### Pre-Application Meeting (PRE21-053)

<b>Site Location:</b>	6950 SE Maker St	<b>Parcel Number</b>	9350900620
<b>Lot Size:</b>	8,750 sf	<b>Zoning:</b>	R-8.4 (Single Family)
<b>Brief Project Description:</b>	Construct 1,000 sf addition to existing single family residence	<b>Documents Provided:</b>	1. Project Questions 2. Survey 3. Site Development Worksheet
<b>Applicant Information:</b>			
<b>Name:</b>	Dorothy Strand	<b>Email:</b>	kcra2005@yahoo.com
<b>Phone:</b>			425-802-1455
<b>Second Pre-application Meeting Required:</b>	Required	Major Single Family Building Permit

**TOPOGRAPHIC & BOUNDARY SURVEY**

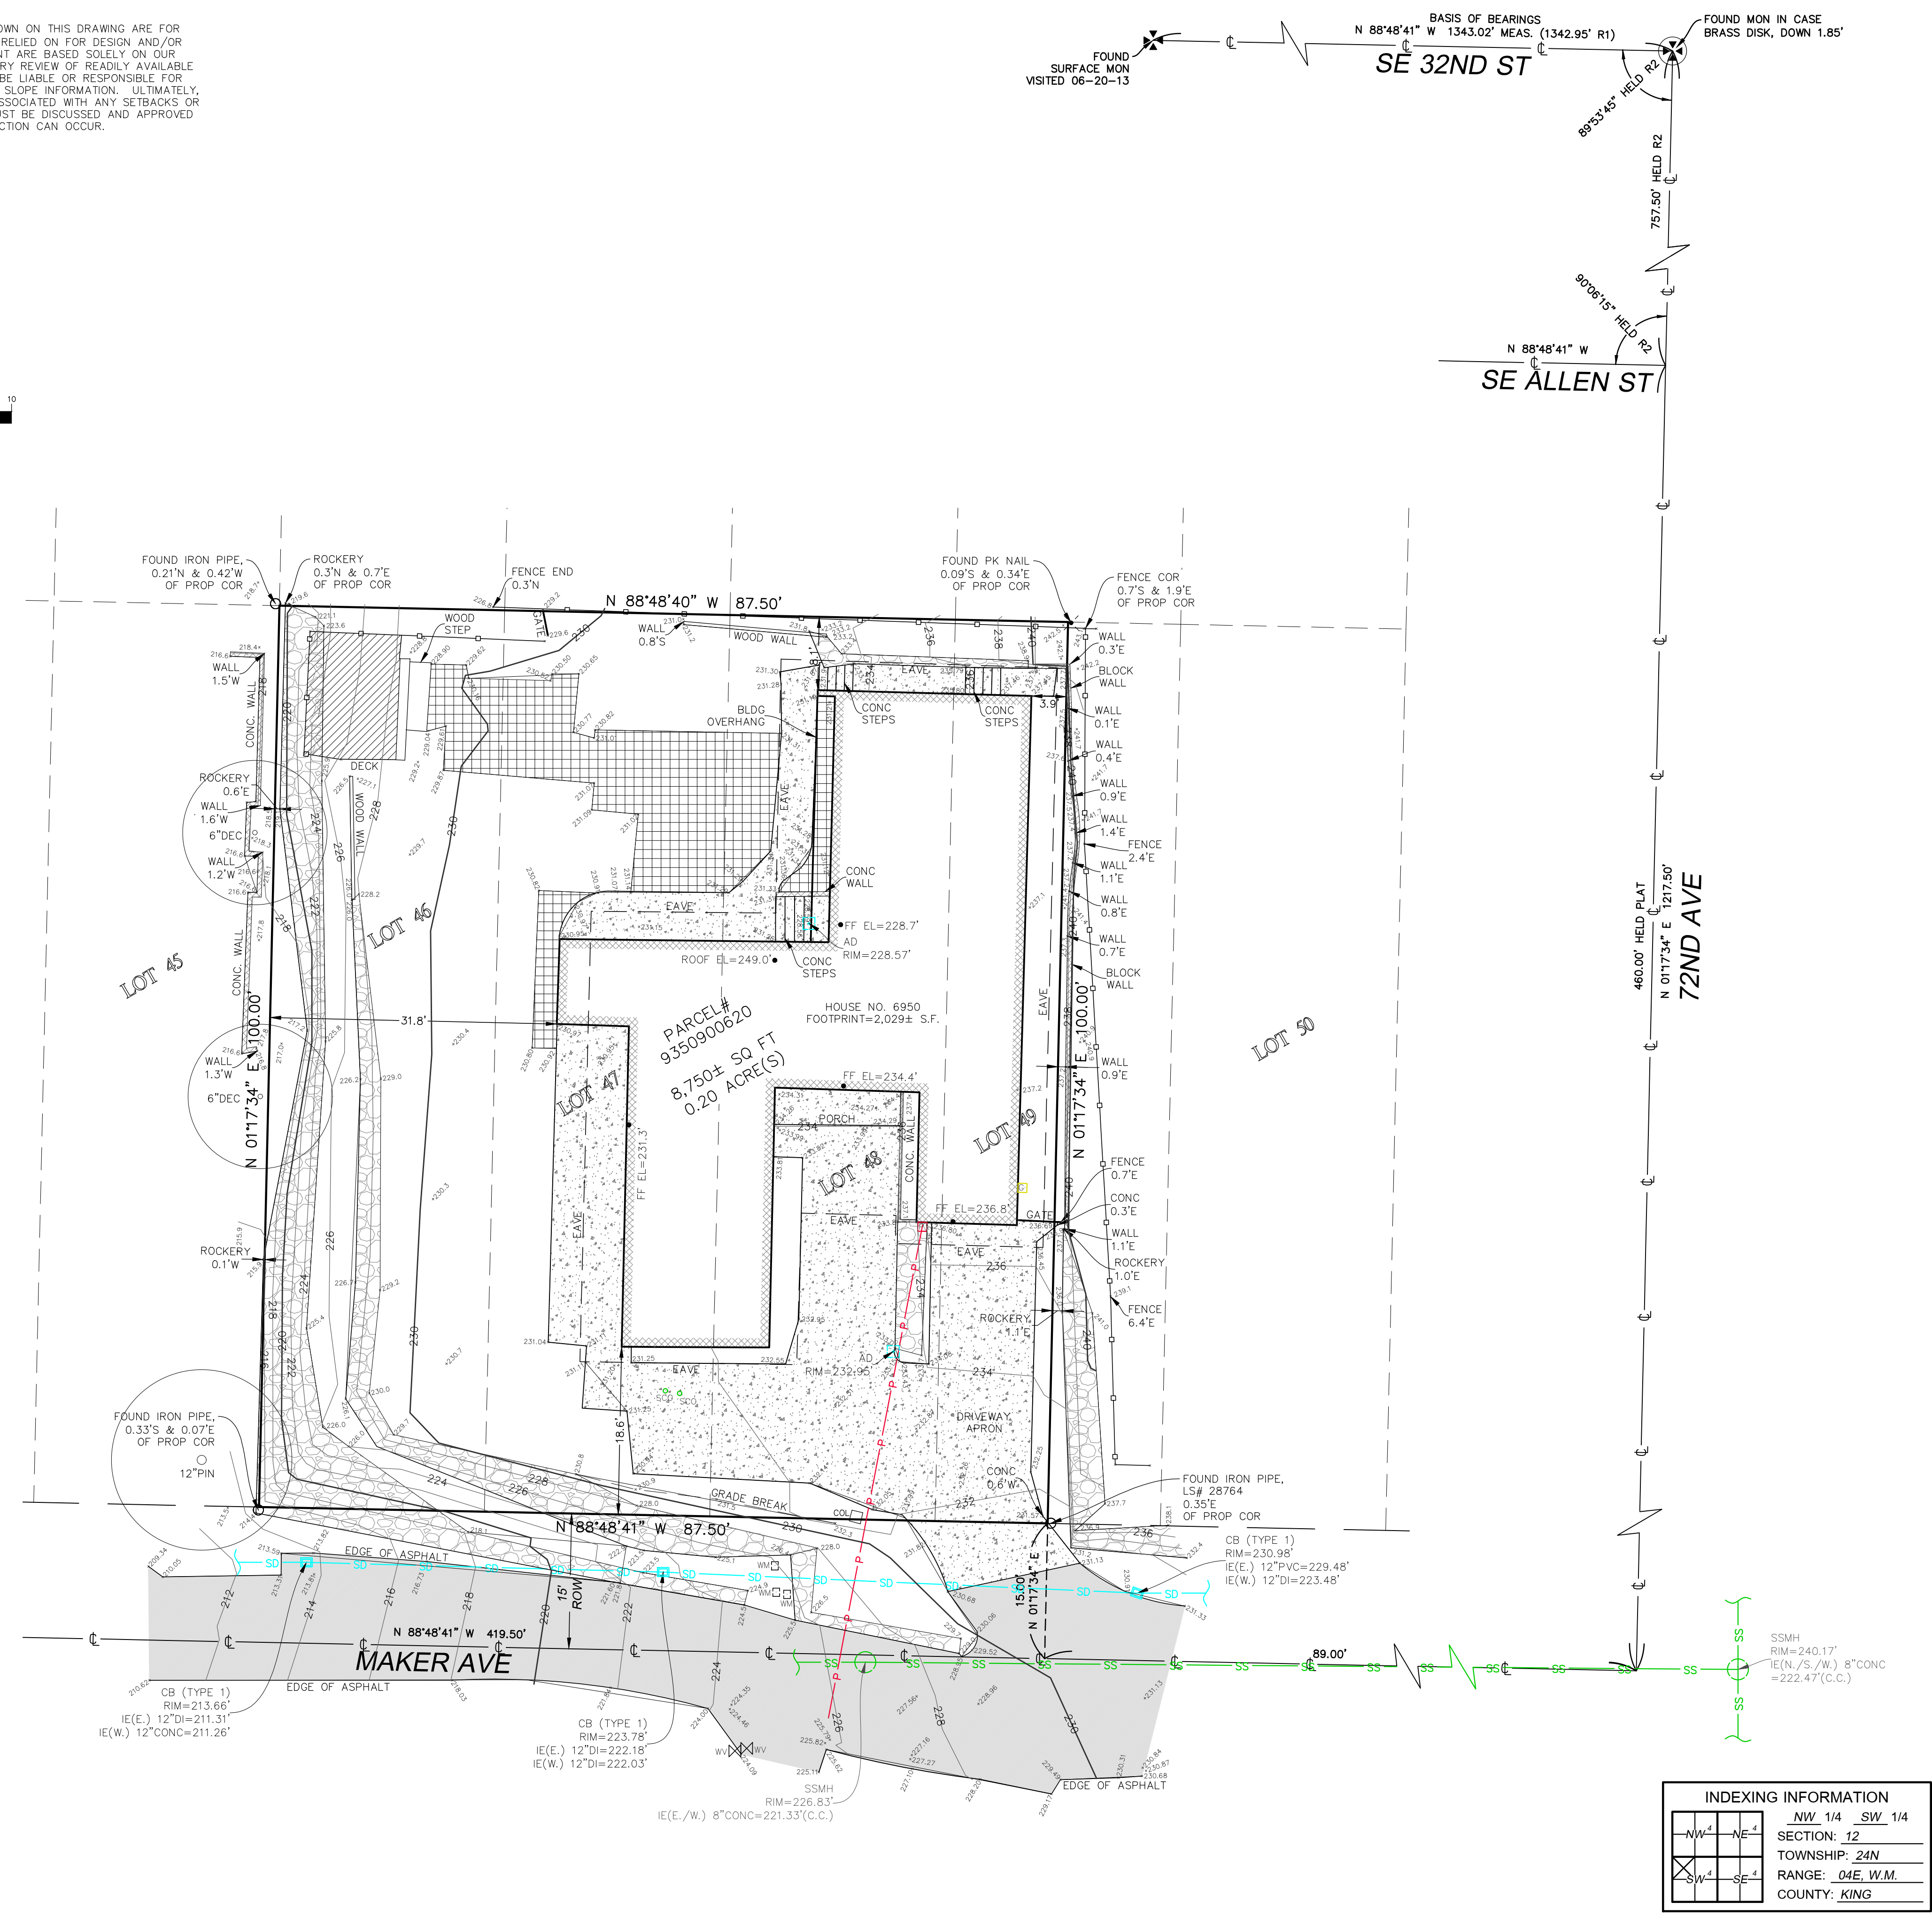
- A. The footprint of the existing residence is not consistent between the survey and King County Assessor's records. The King County Assessor shows the following footprint:

The survey shows the following footprint:

There is no City or County record of an approved building permit for the portion of the building identified by the red bubble above. Please provide an approved building permit that authorized this addition or sufficient documentation that it was exempt from a building permit. This portion of the structure is not considered legal until the documentation is provided.
